From: Nicola Oktay on behalf of Planning.Responses
Sent: 10 June 2025 12:28
To: Planning Scanning
Subject: FW: Planning Consultation on: BR/64/25/PL

Arun Private Sector Housing response

Application No: BR/64/25/PL
Registered: 14th May 2025
Site Address: 3 and 4 Queens Square Bognor Regis PO21 1SA
Grid Reference: 493658 99377
Description of Works: Change of use from 2 No separate adjoining bed and breakfast accommodation units (each having owners accommodation, communal lounge and dining areas at ground floor and 7 No B&B bedrooms at first and second floors) to 10 No flats. This application is in CIL Zone 4 (Zero Rated) as flats.

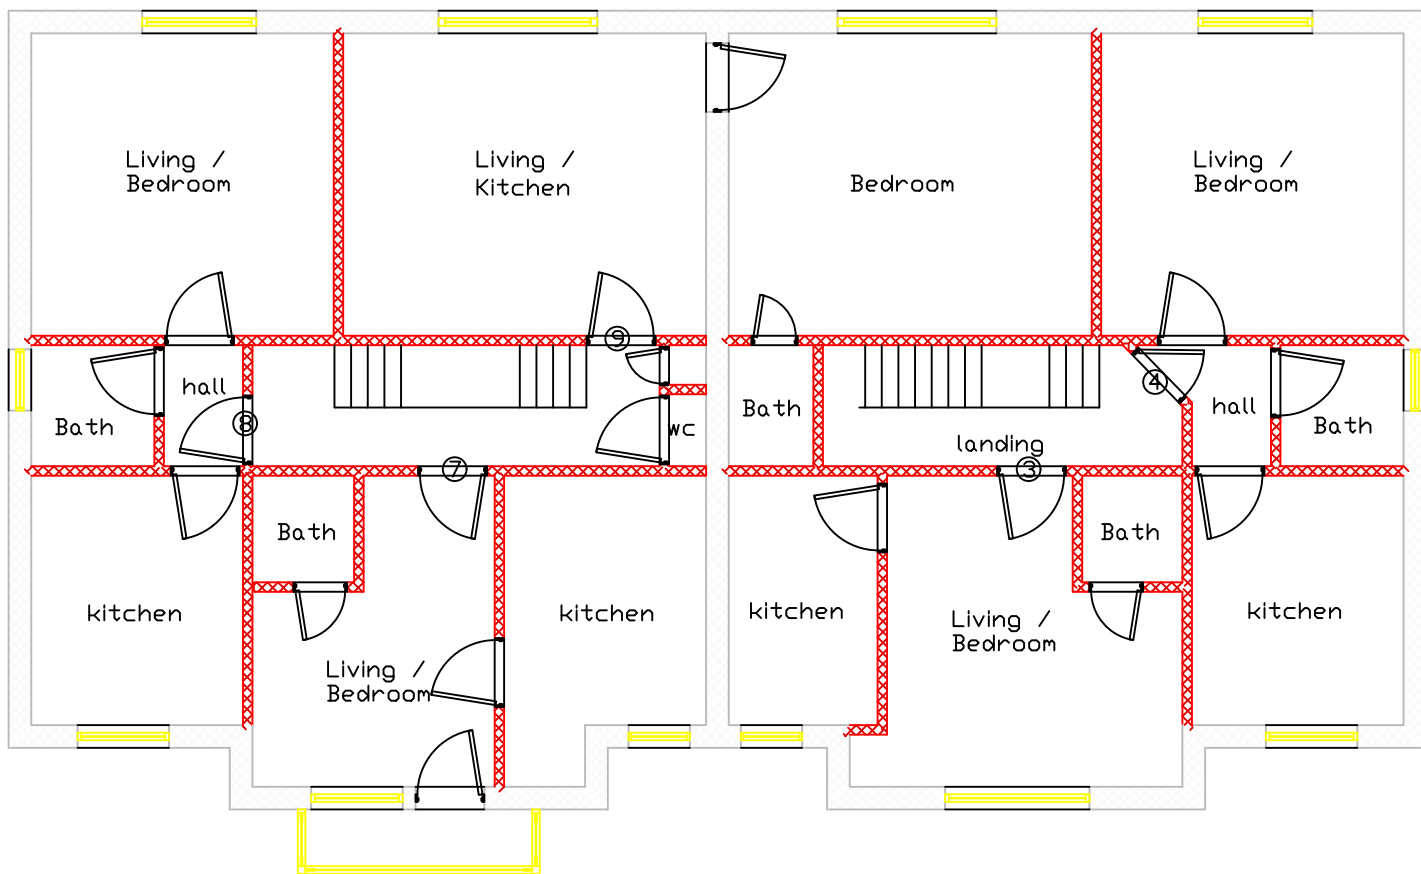
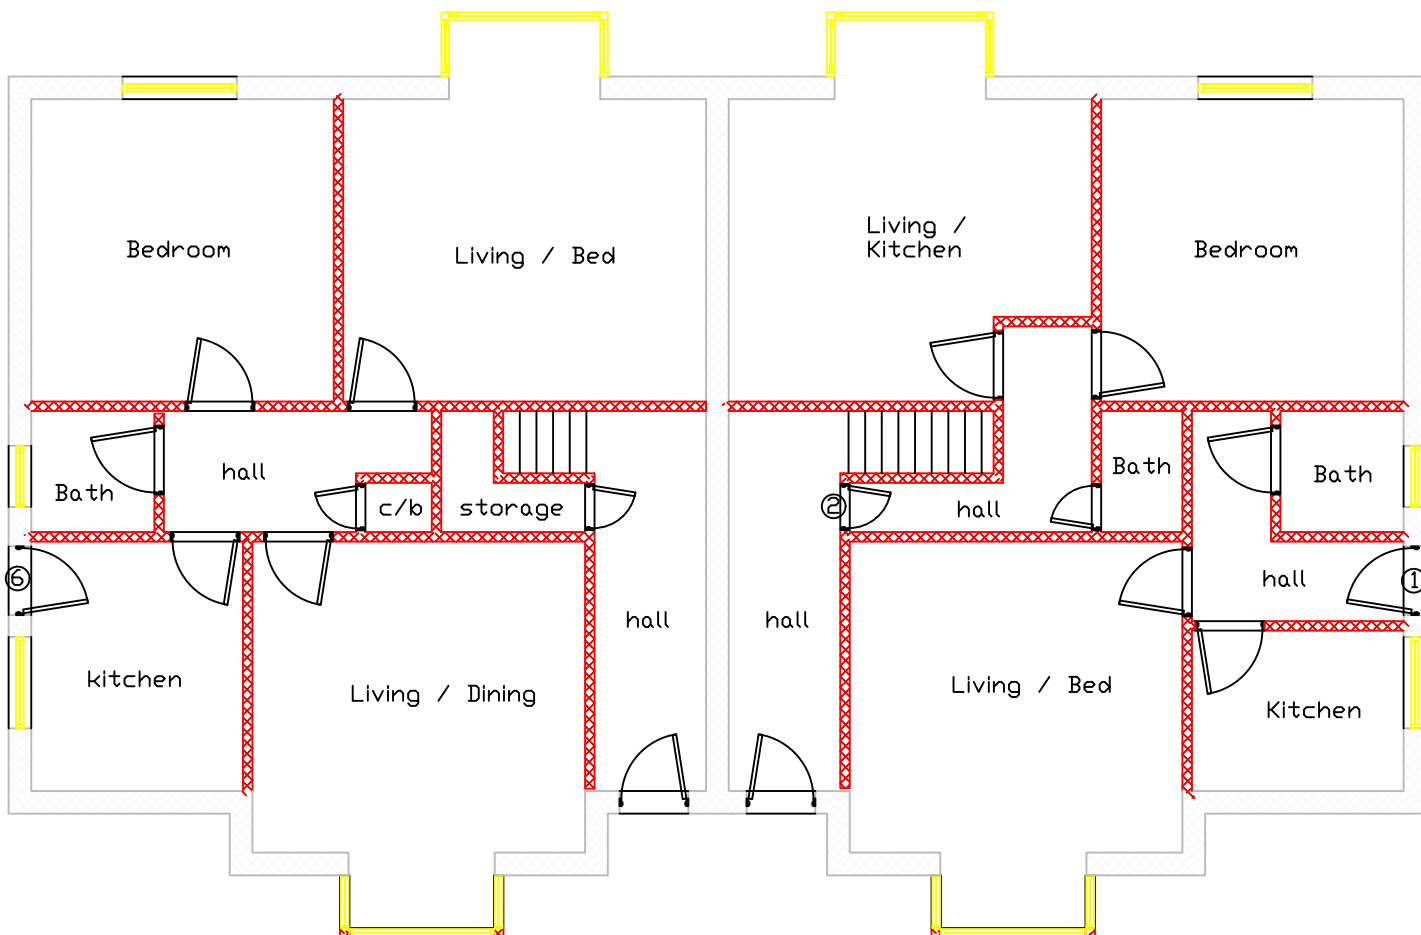
- Flats 6 & 9 both comprise inner rooms where additional fire safety precautions will be required. A room where the only escape route is through another room is termed an “inner room” and poses a risk to its occupiers if a fire starts unnoticed in the outer room.
Flat 6 – As egress is via the kitchen, the following additional fire safety measures should be installed: Fire door to FD30 standard to be fitted between the kitchen and hall, smoke detection installed within the hall and an escape window installed to one of the inner rooms
Flat 9 – As egress is via the living/kitchen, the following additional fire safety measures should be installed: Fire door to FD30S standard to be fitted between the living/kitchen and bedroom, smoke detection installed within the living/kitchen to provide early warning of a fire and an escape window installed to the bedroom
However, consideration should be given to reconfiguring the layout of both flats to prevent inner rooms

- The bathrooms in flats 5 & 10 appear to be extremely narrow and compact, increasing the likelihood that the users would potentially collide with their surroundings (walls, amenities etc). This could be identified as a hazard under the Housing Health and Safety Rating System (HHSRS), therefore consideration should be given to reconfiguring the bathrooms to provide a better space and layout.

- The roof casements serving flats 5 & 10 should be of an appropriate height and angle to provide a reasonable view outside of the immediate surroundings
